From: David Easton [REDACTED]
Sent: 05 June 2018 [REDACTED]
To: Jen Samuelson
Cc: Claire Potts
Subject: RE: Land west of New Barn Lane - non material amendment

The proposal relates to Land west of New Barn Lane (RM approved under BE/113/17/RES).

My client would like to replace the substation towards the south of the site with a double garage to serve plot 9 (same design as other garages on the site), to be accessed from the same location as the substation. The land to the east of Plot 9, where the parking is currently shown, would be reverted to landscaping with a footpath from the garage to the front door and the street.

scheme: Land West of New Barn  
Lane, North Bersted  
client: Linden Homes  
drawing: Landscape Proposals  
date: July 2017  
scale: 1:200@A1  
drawing no: LIN21257 12D Sheet 2  
drawn: LS checked: AE

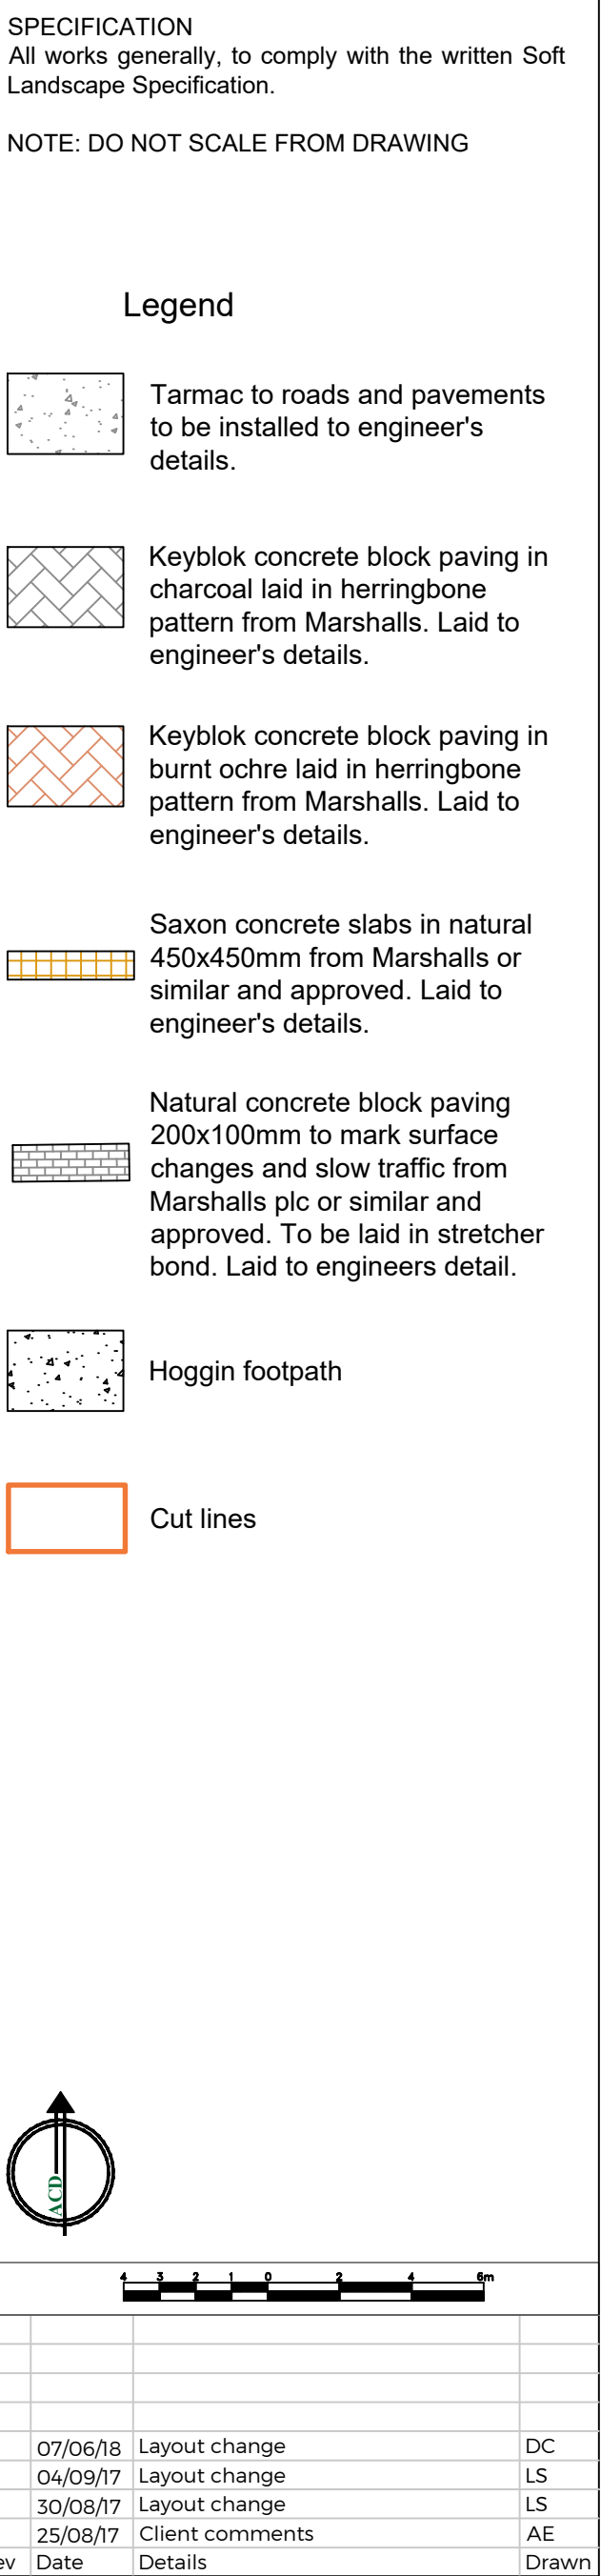
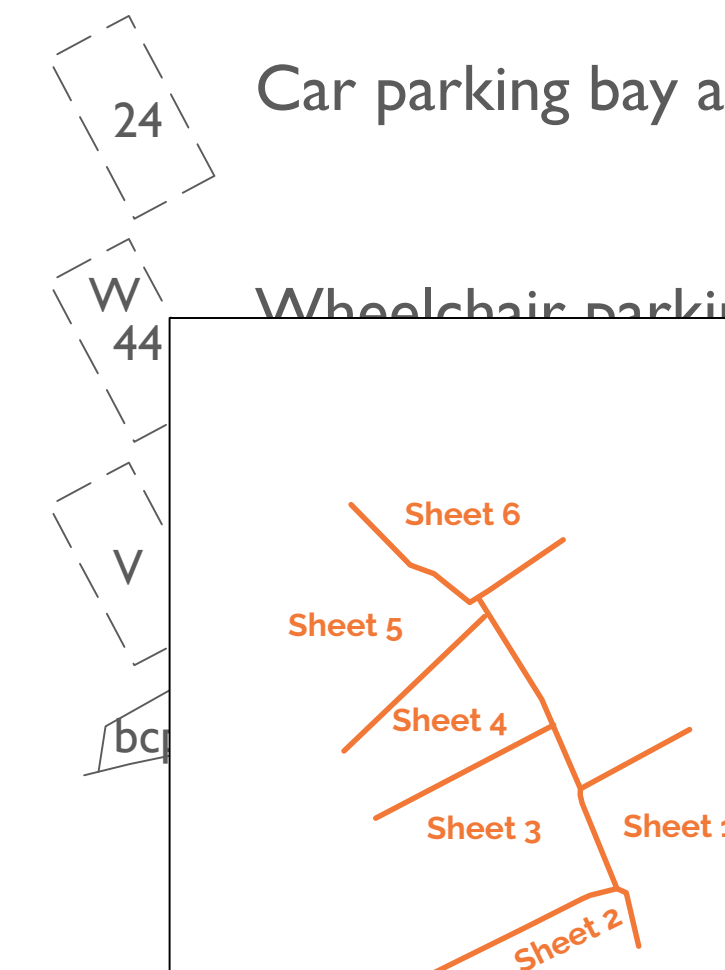
I have looked at the previous reserved matters application under reference BE/113/17/RES and have noted that the proposed double garage (drawing no. 16-1103-070-A) would measure approximately;

Height – 4.4m
Width – 6.5m
Length – 6.7m

I was unable to identify any elevational drawings for the substation but the site plan showed the substation as measuring approximately;

Width – 4.15m
Length – 3.91m

With the dimensions of the proposed garage in comparison to the sub-station as shown on drawing no. 16-1103-009-A I do not believe that the proposed amendment would accord with the Council's guidance and as such could not be considered as a non-material amendment. The Council's guidance in relation to non-material amendment applications can be found [here](#).

I have spoken with Neil Crowther (Head of Planning) this morning who has advised, that whilst the proposal fails to accord with the adopted guidelines, we can accept an NMA in this case as the development has not been built and as such will not result in any harm to existing residential properties.
